WEST SUSSEX COUNTY COUNCIL CONSULTATION

TO:	Arun District Council FAO: Amber Willard
FROM:	WSCC – Highways Authority
DATE:	21 April 2026
LOCATION:	Royal Oak, Pagham Road, Chichester, PO20 1LN
SUBJECT:	P/39/26/PL Change of use of the ground floor only from former public house (sui generis) to kitchen and bathroom showroom (Use Class E), with internal alterations and replacement of existing above-ground signage on existing fixings only.
DATE OF SITE VISIT:	n/a
RECOMMENDATION:	Advice

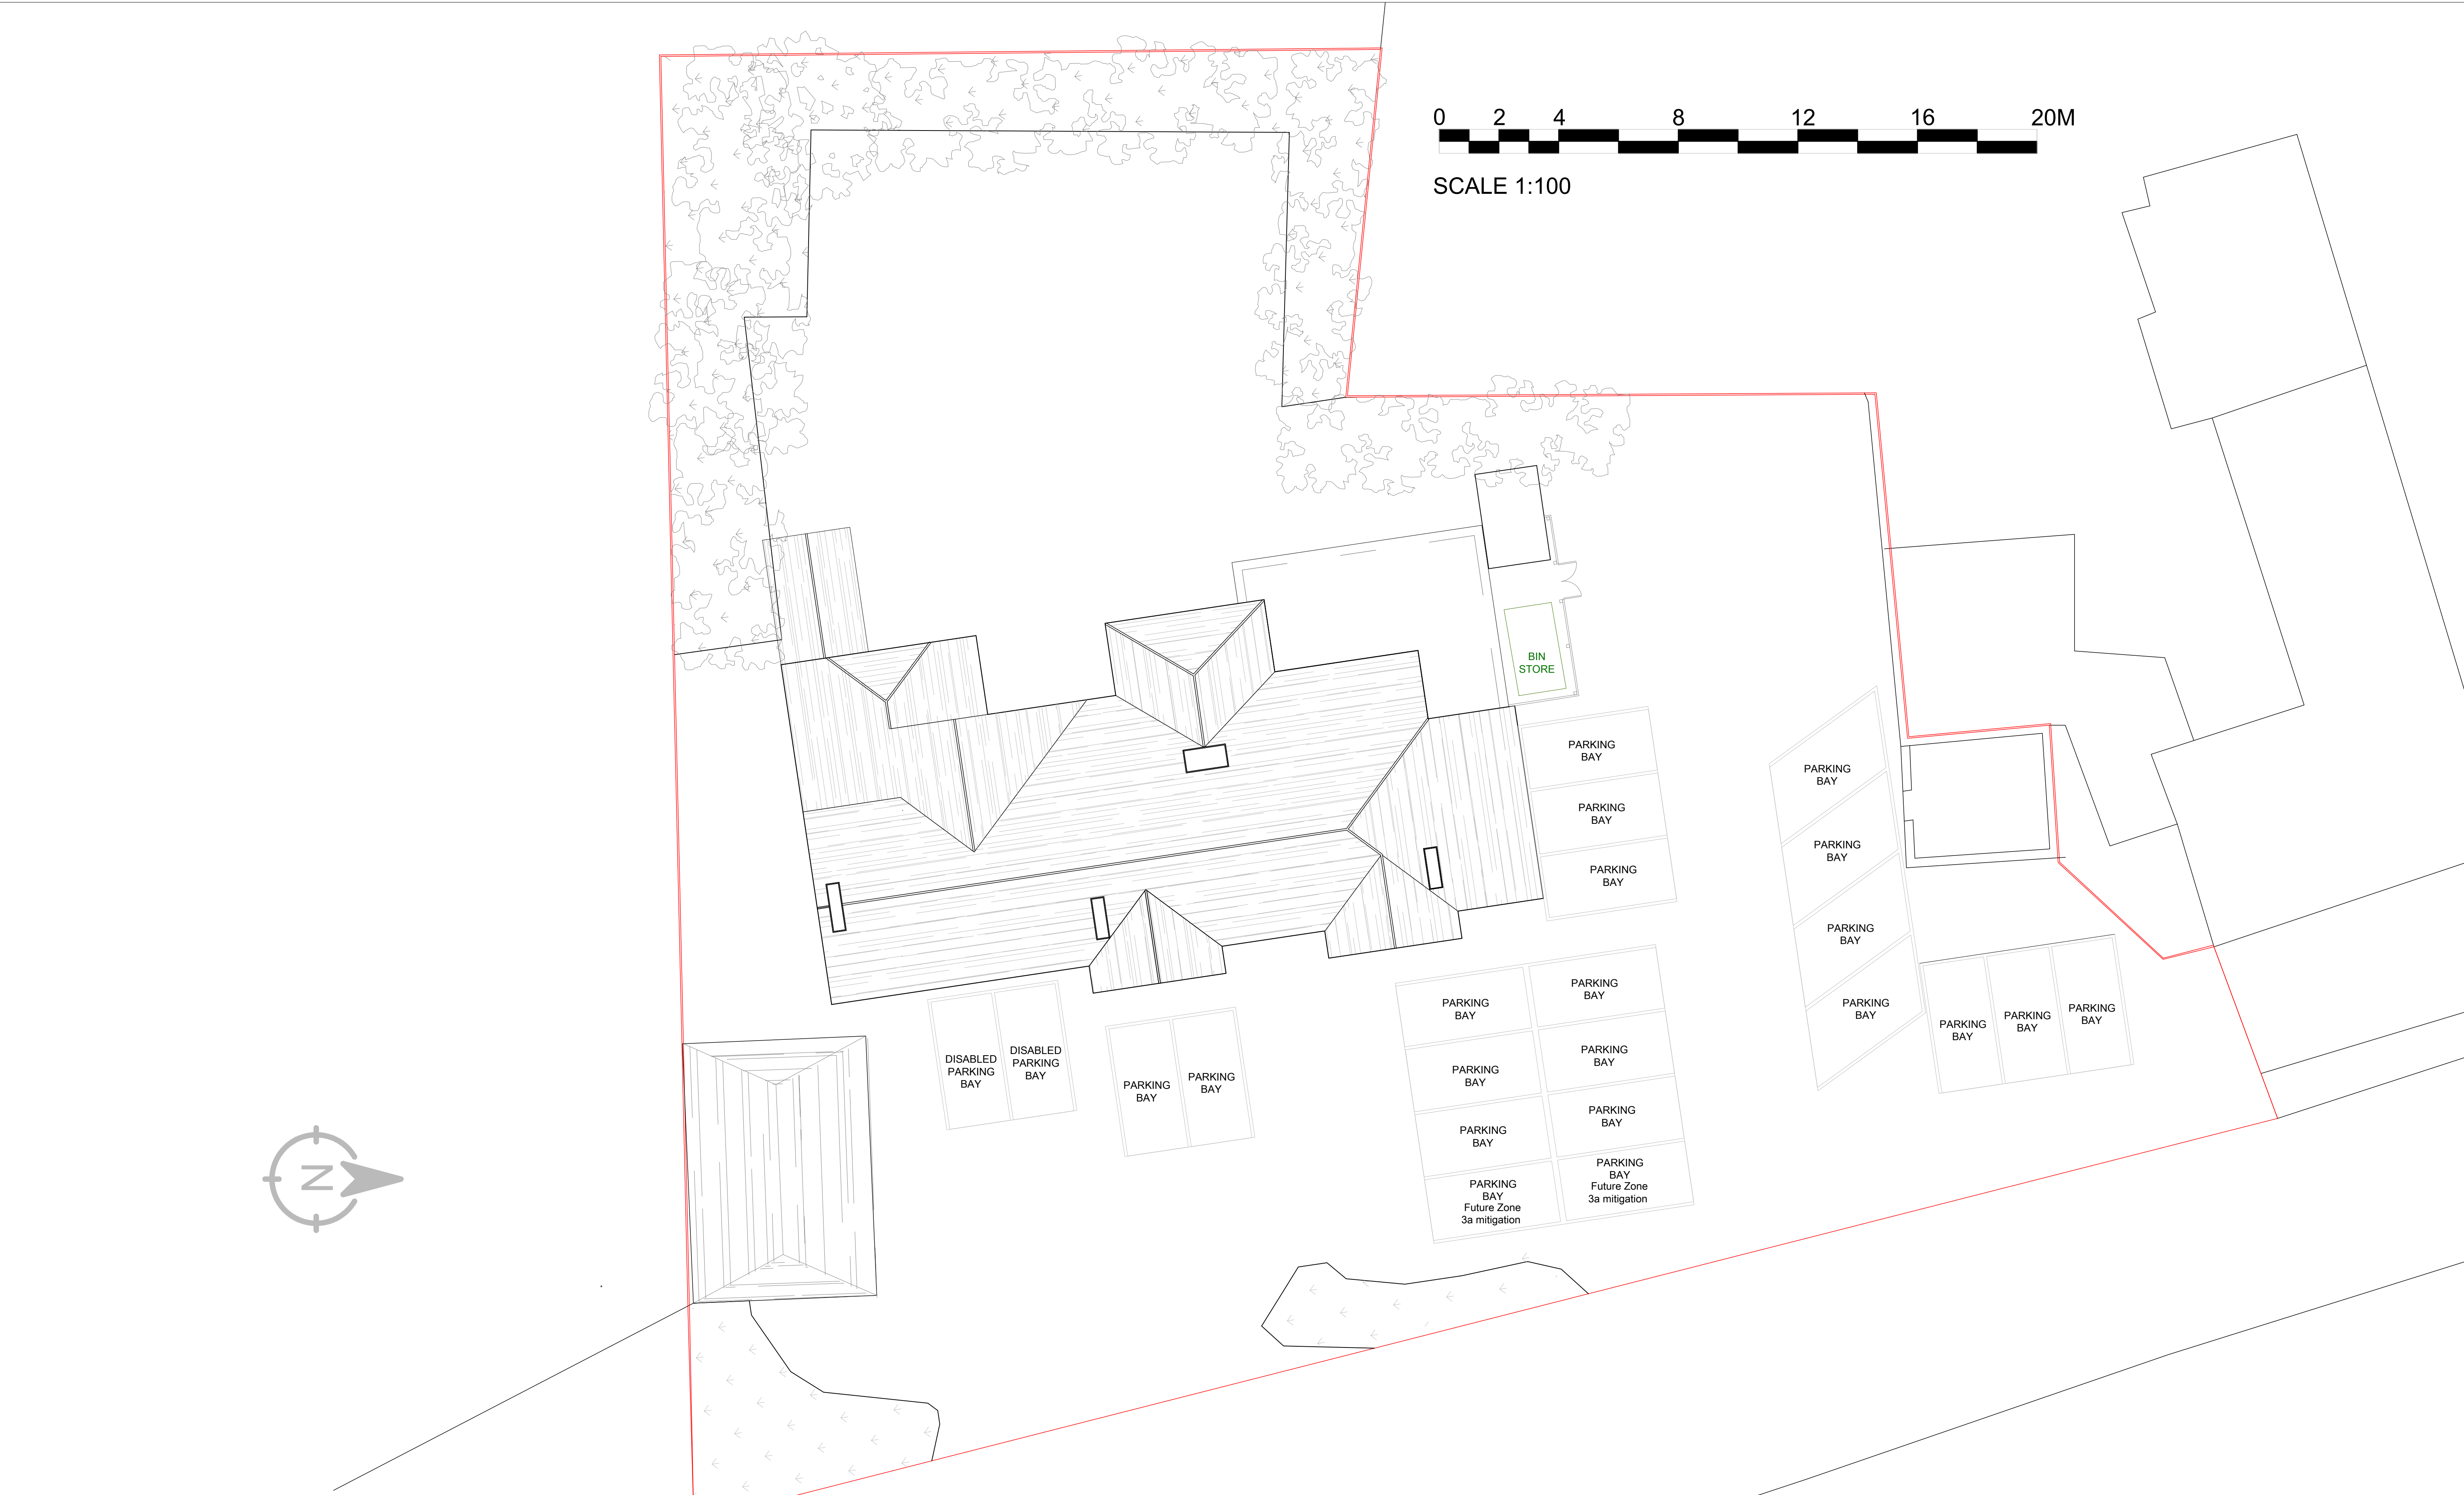
There are no proposed changes to the existing access arrangements. An inspection of collision data provided to WSCC by Sussex Police from a period of the last five years reveals nine recorded collisions within the vicinity of the site. However, they were not attributed to the use of the site access or site operation. Therefore, there is no evidence to suggest the site access has been operating unsafely, or that its continued use would exacerbate an existing safety concern.

The existing car park will remain unchanged with parking for 22 cars. Under Arun parking standards a development of this size in this location would require 18 car parking spaces. Therefore, the LHA is satisfied with the proposed level of parking provision.
